Liverpool Health & Academic Precinct
MSCP SSD-10388

28th of September 2021

SSD MODIFICATION

LIST OF PROPOSED MODIFICATIONS

PROJECT NO.
21807
DRAWING NO.
A-SSDA-MSCP-15
ISSUE
08
STATUS
SSDA AMENDMENT

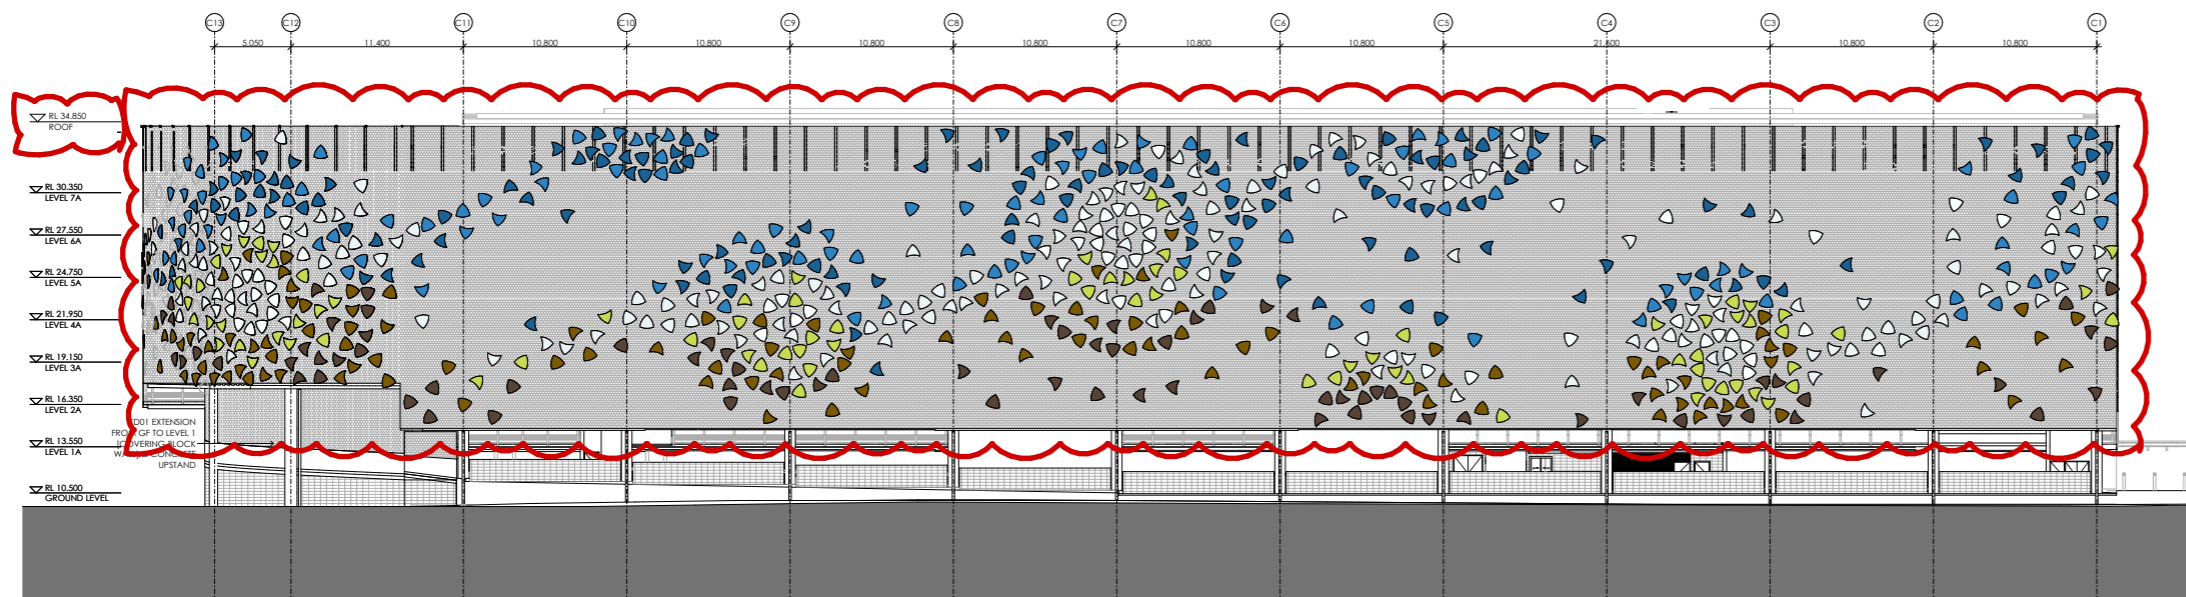
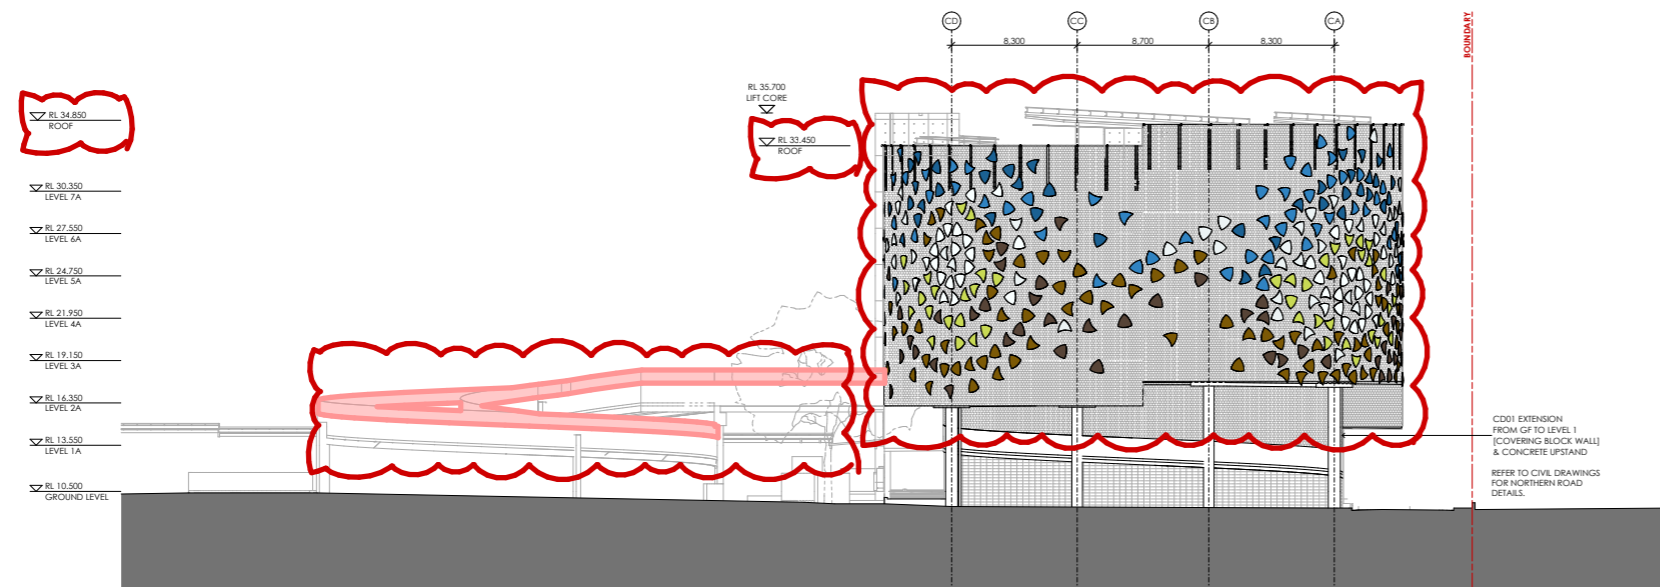
- + A new 2.2m high perforated steel safety screen along the length of the spiral entry and exit ramp
Reason: to provide additional safety and a higher level of fall protection

- + Incorporation of a new artwork in place of the previous façade design
Reason: incorporation of an artwork in accordance with previous consultation undertaken and SSD Clause D26 relating to public art.

PROJECT NO. 21807 DRAWING NO. A-SSDA-MSCP-27 ISSUE 08
STATUS SSDA AMENDMENT

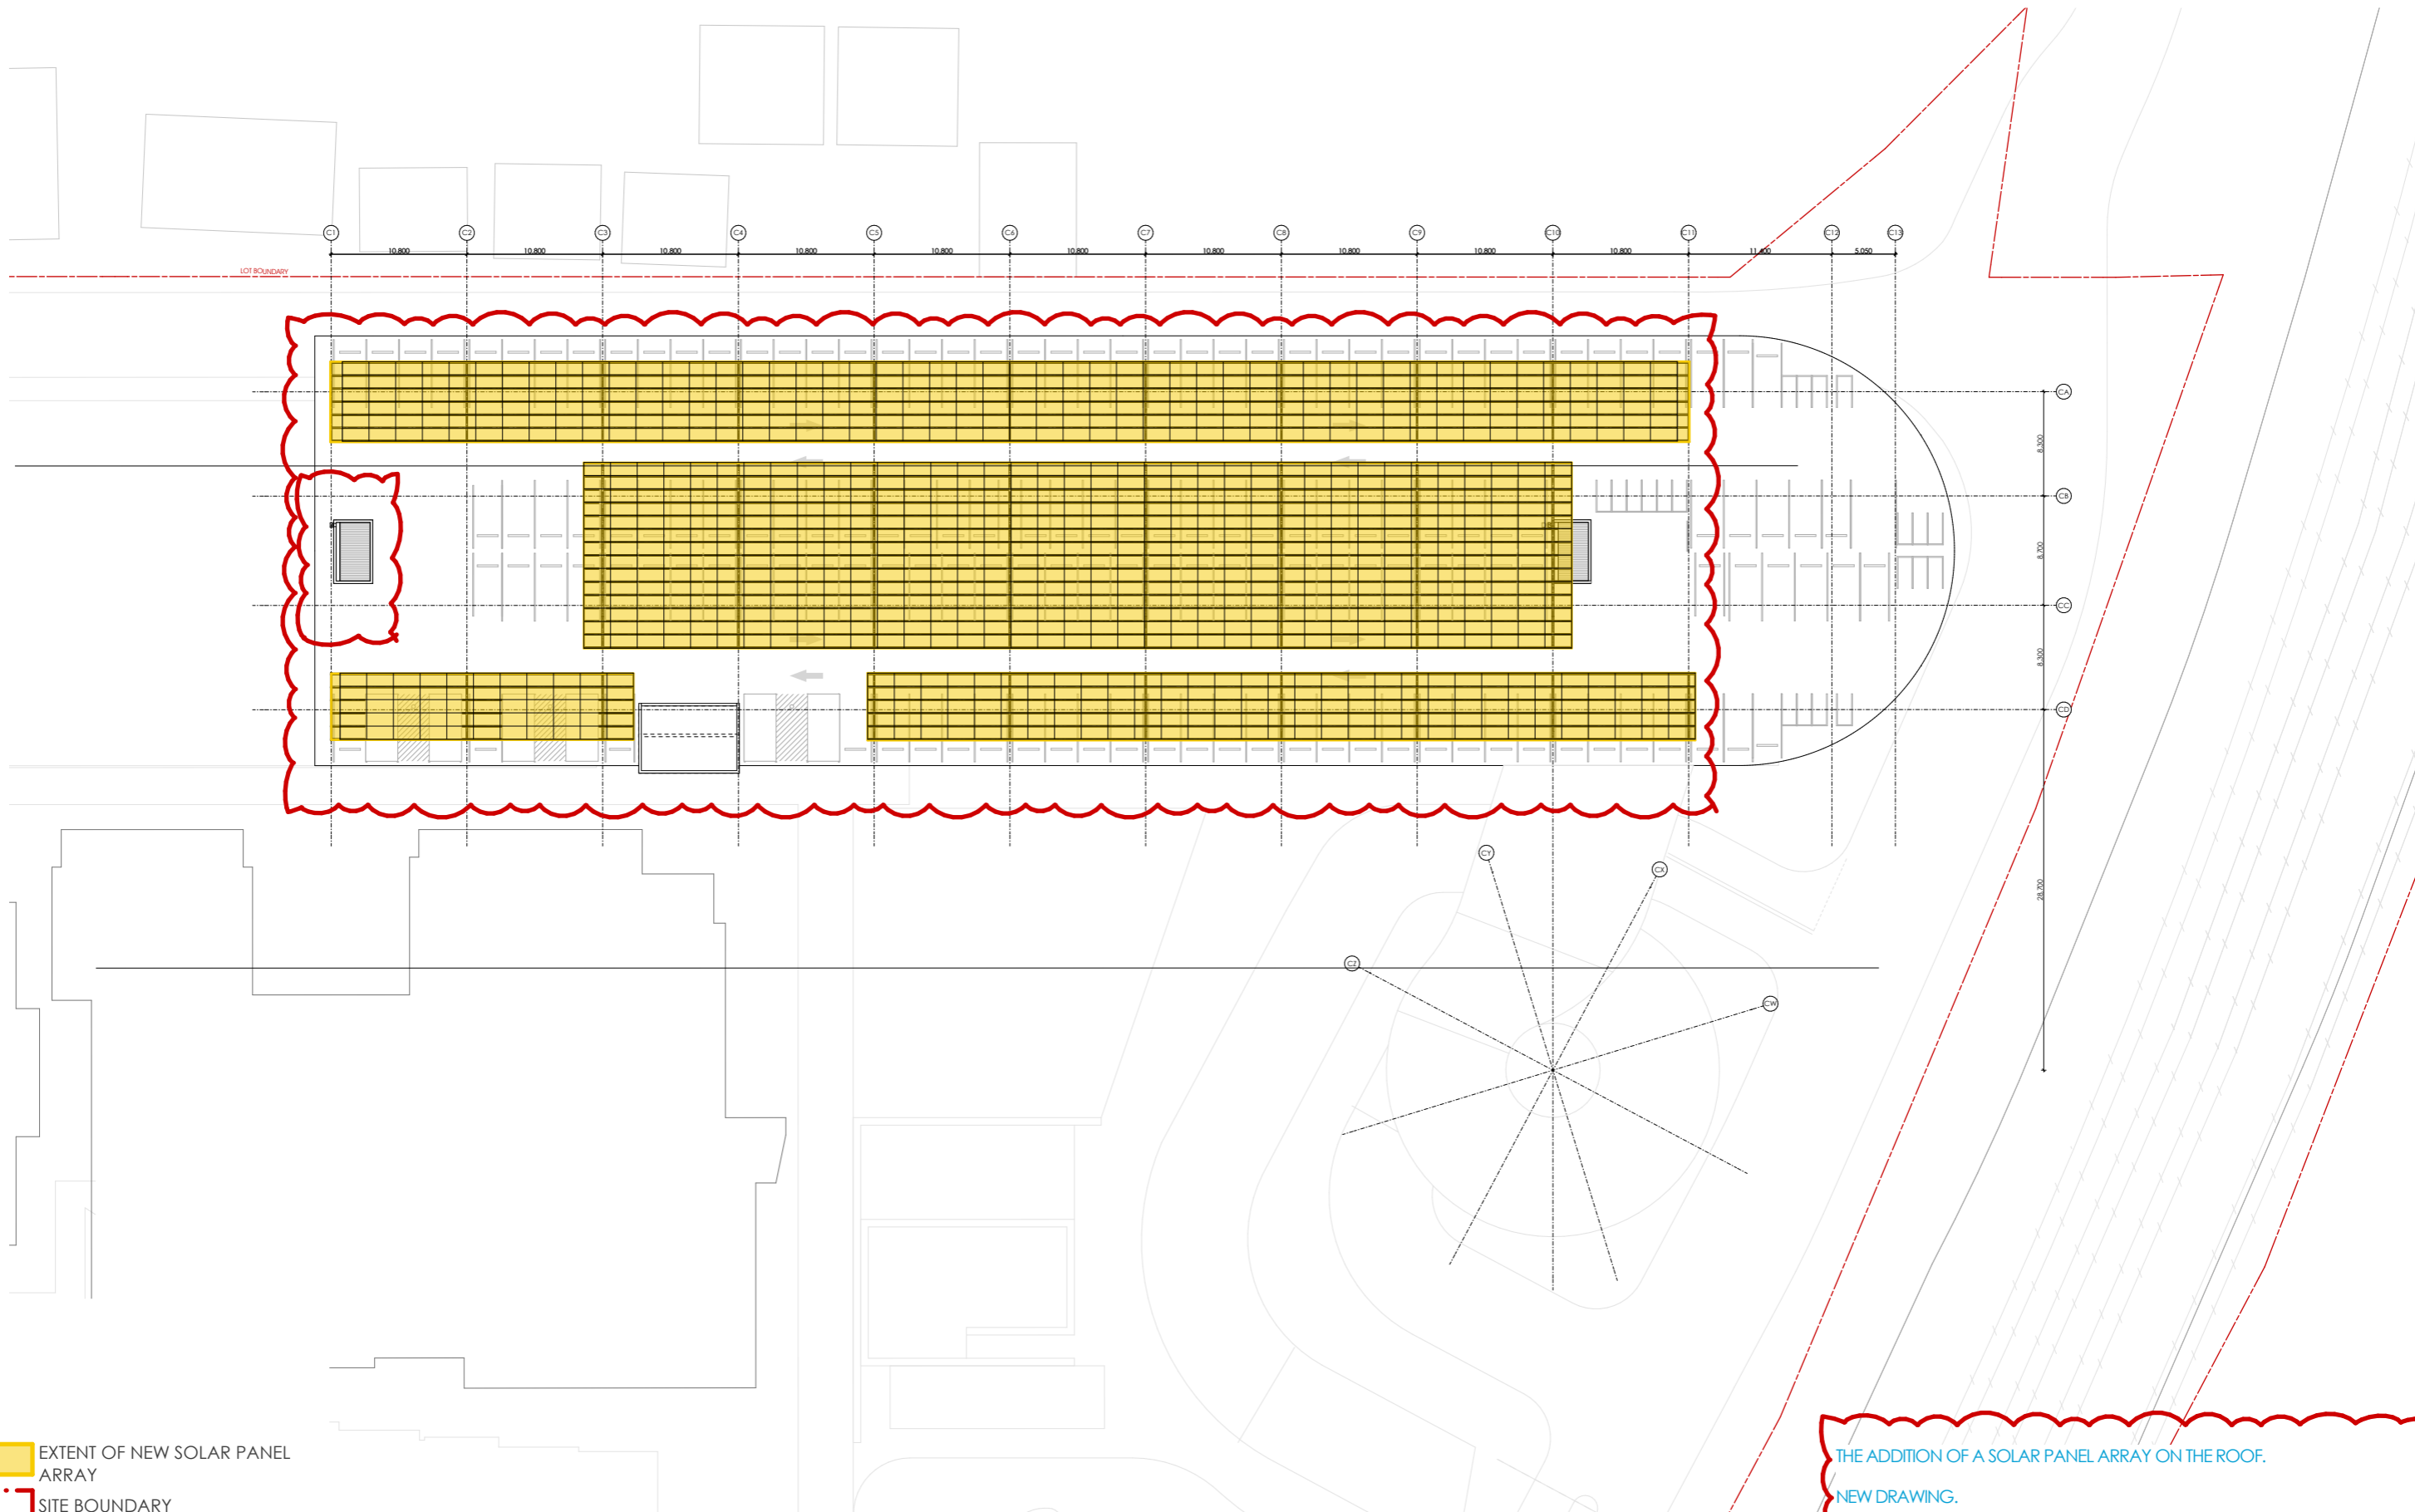
- + A new solar PV array and associated support structure on the roof level, resulting in the loss of one car space (revised total is 1244 spaces)
Reason: additional infrastructure to provide a higher level of sustainable design and a long term, sustainable energy source for the hospital campus

- + Six additional accessible spaces on the roof level, resulting in a loss of three car spaces (revised total is 1244 spaces)
Reason: additional parking amenity for people with special needs
